STERLING RANCH FILING NO.2

STREET IMPROVEMENT PLAN

MAY 2020

Engineering Review
07/31/2020 12:19:50 PM
dsdrice
JeffRice@elpaso.com
(719) 520-7877
EPC Planning & Community Development Department
See comment letter also.

BYNUM DRIVE
STA 0+00.00 TO STA 9+24.77

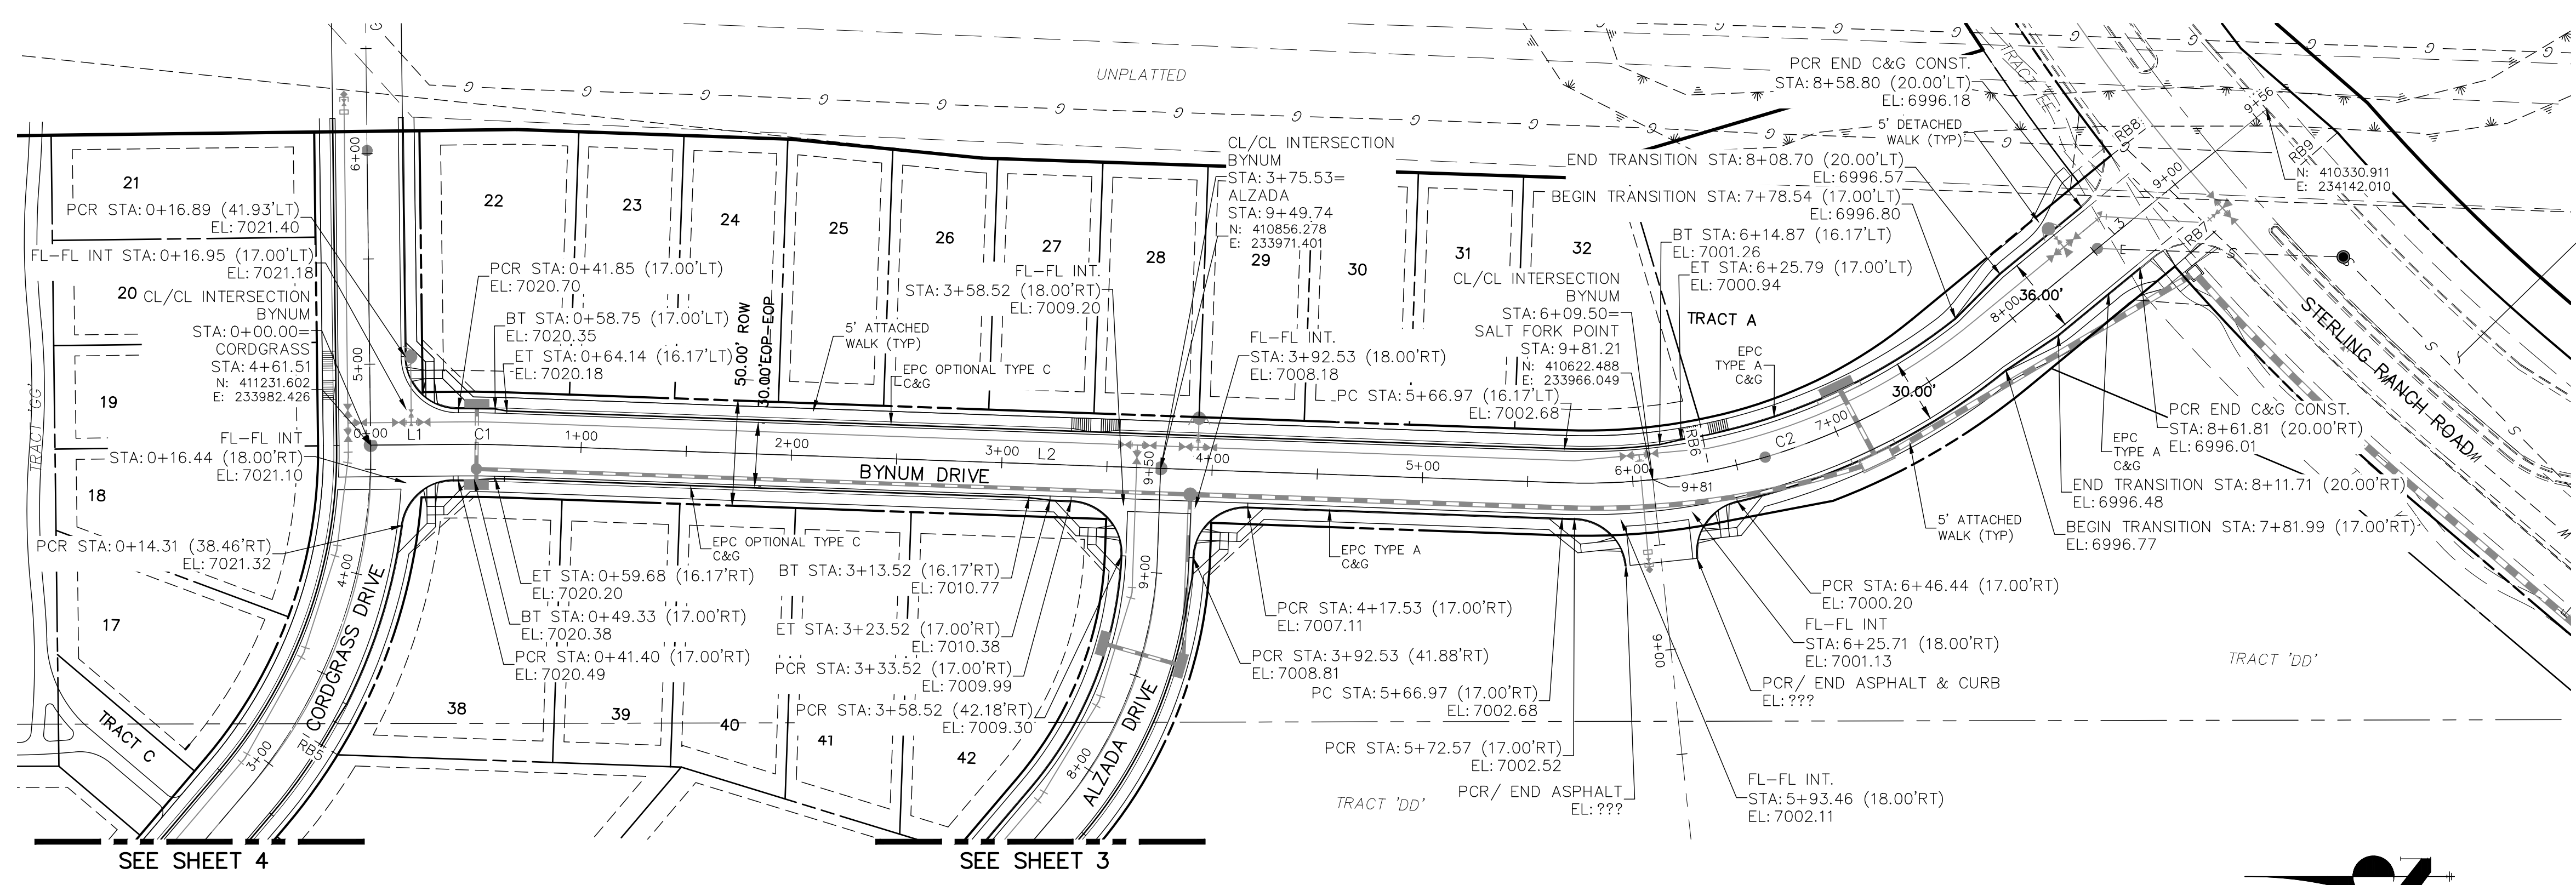
Preliminary Plan typical section here ("D") is different - collector.
